Charlotte Department of Transportation

Memorandum

Subject: Rezoning Petition 08-035: Located on both sides of Statesville Avenue
between Woodward Avenue and Dearborn
Avenue

VICINITY MAP
Not To Scale

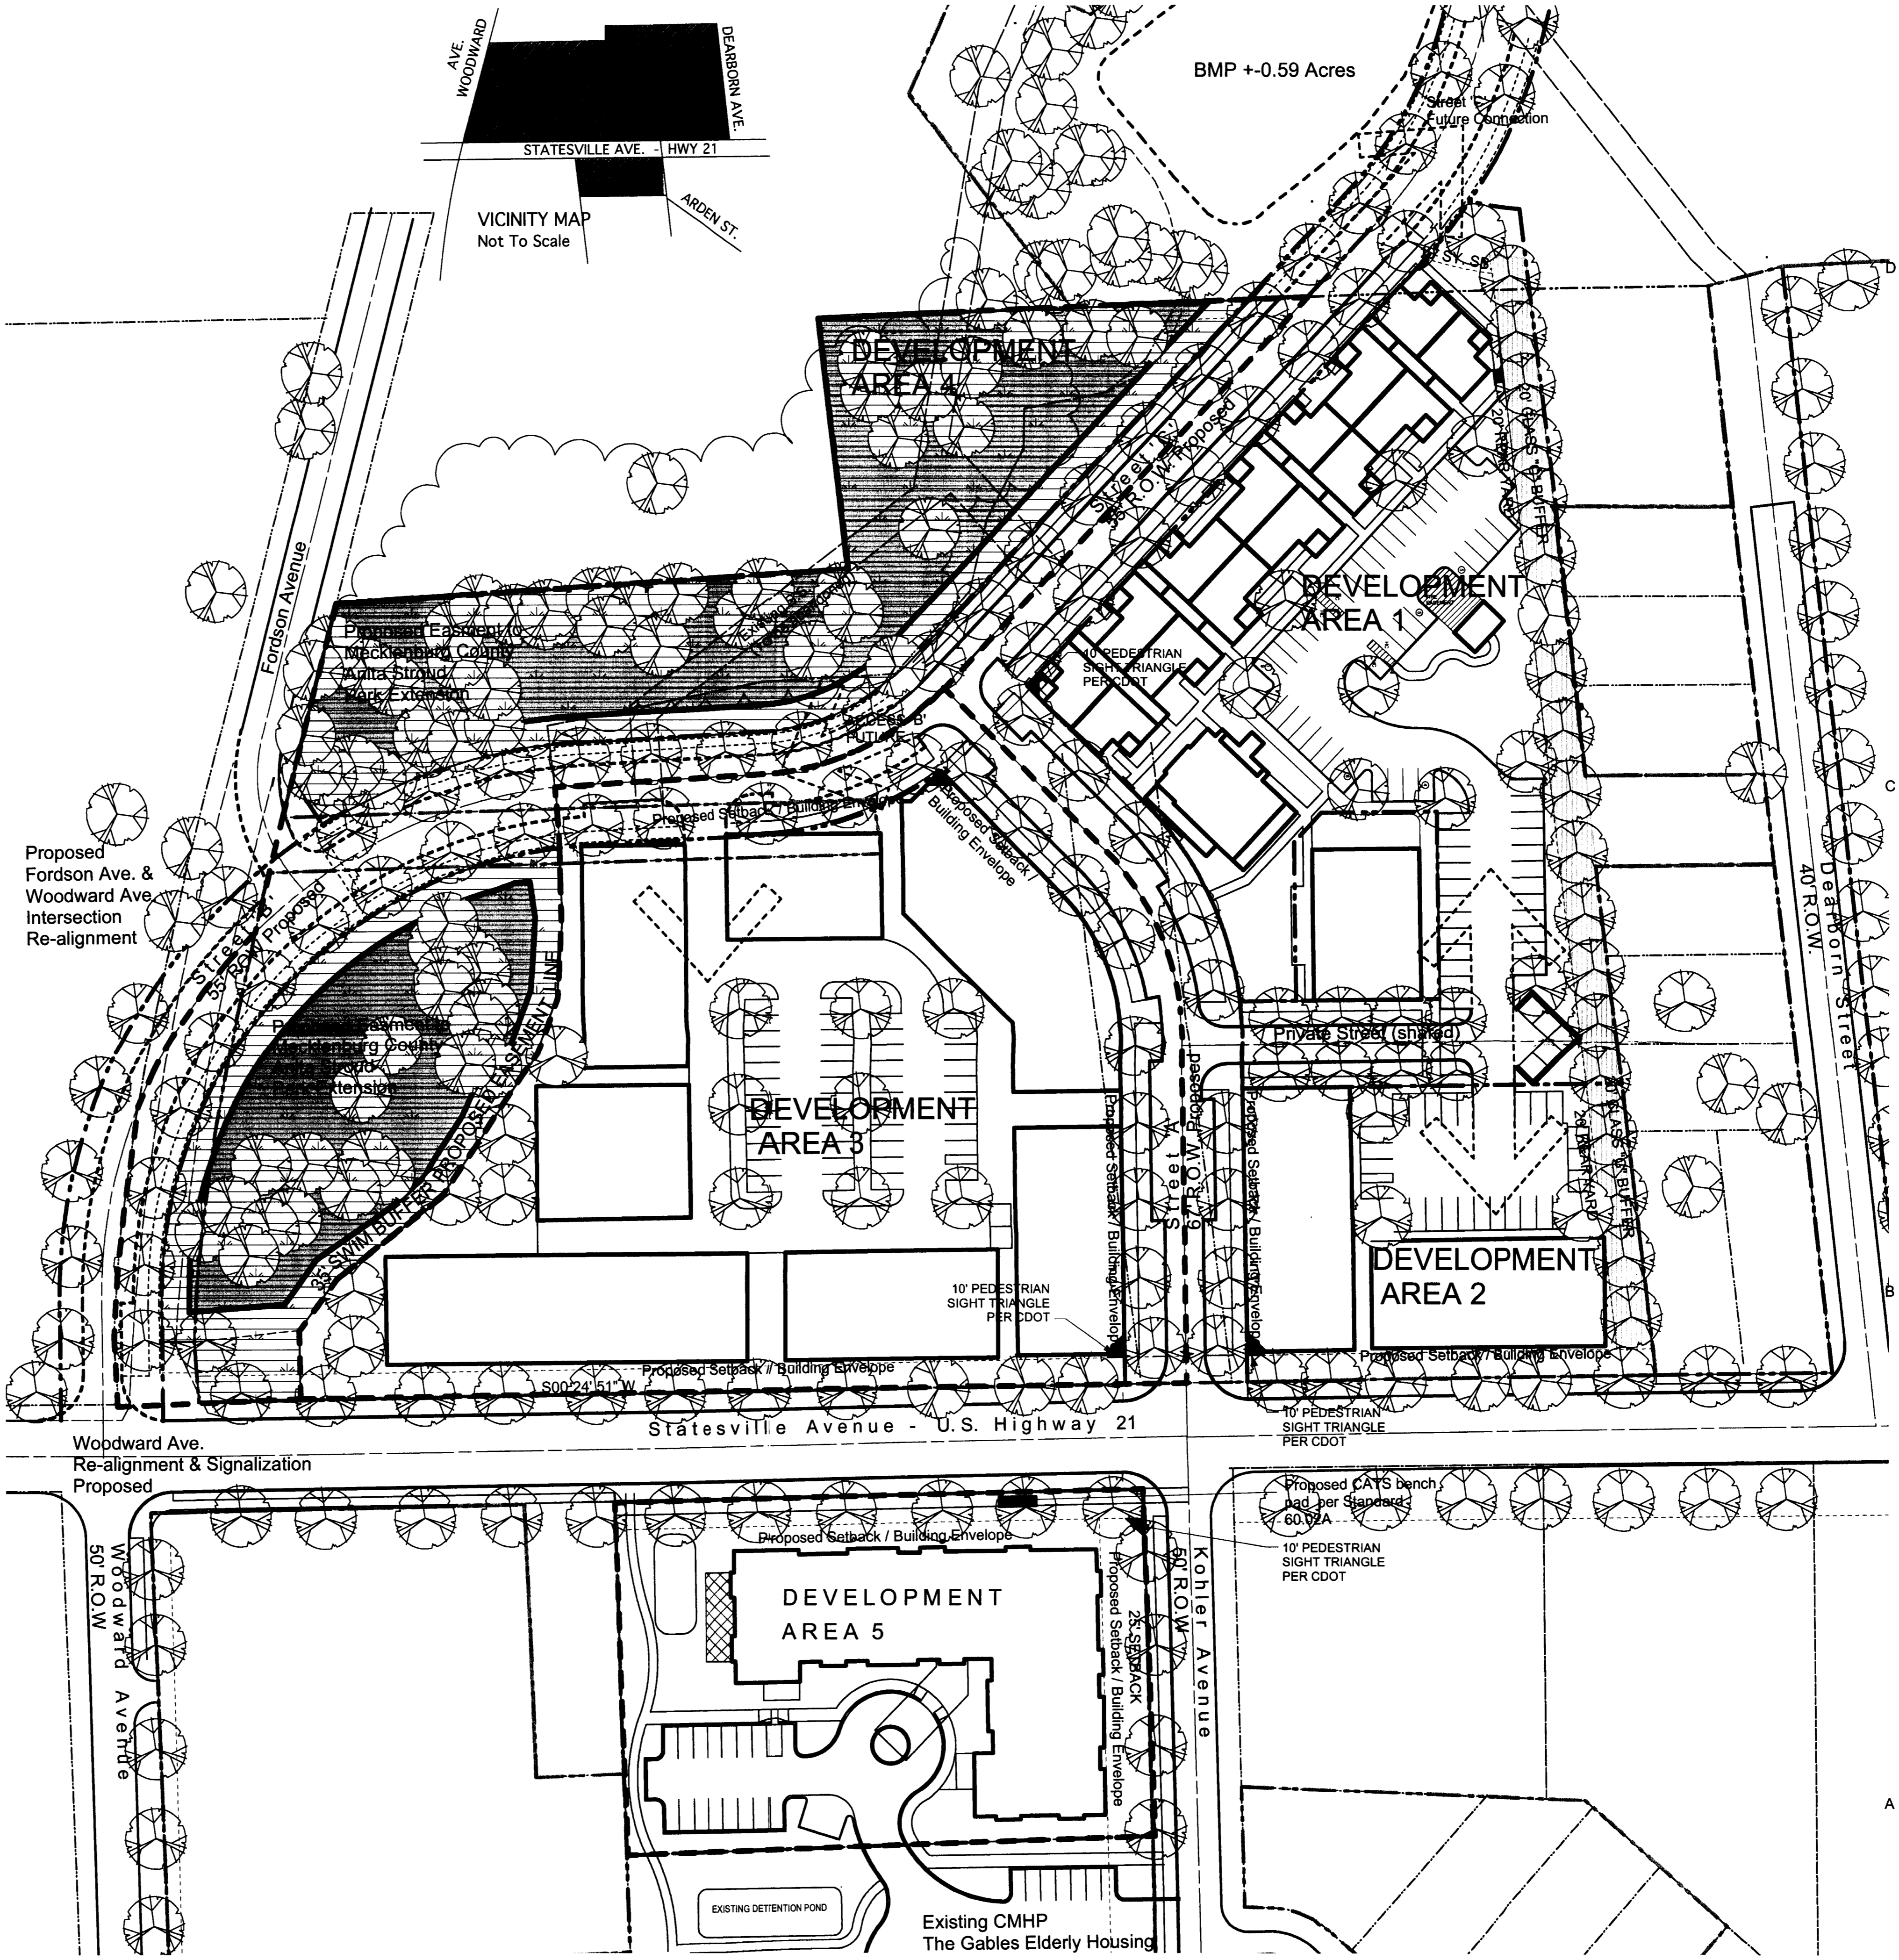
1. The site plan shows a proposed realignment of Fordson/Woodward Avenues to directly connect as the 4th leg of the existing Statesville/Woodward intersection. This proposed realignment and necessary improvements will be further reviewed by CDOT and the NCDOT during the review of the TIS.
2. The proposed realignment of Woodward Avenue is shown on an adjacent parcel (075-105-28). This property needs to be acquired before the realignment can be approved.

3. Development Area 1 on the plan shows a future connection to a future or existing street. This connection is too close to the intersection of proposed Woodward Avenue and this street and needs to be removed from the plan.

4. Many of the Development Areas do not indicate proposed access locations. All proposed access locations to existing and proposed public streets need to be shown on the site plan. Access will not be approved on Statesville Road to serve Development Areas 2, 3, and 5 and the un-numbered Development Area adjacent to Development Area 5. Access to these development areas must be provided by streets internal to the development.

5. The proposed realignment of Woodward Avenue directly affects the access to an adjacent elementary school. The petitioner needs to demonstrate that the realignment will not adversely affect stacking for student pick up at the school. The petitioner needs to have discussions with the school/CMS and accommodate the needs of the school with their roadway design.
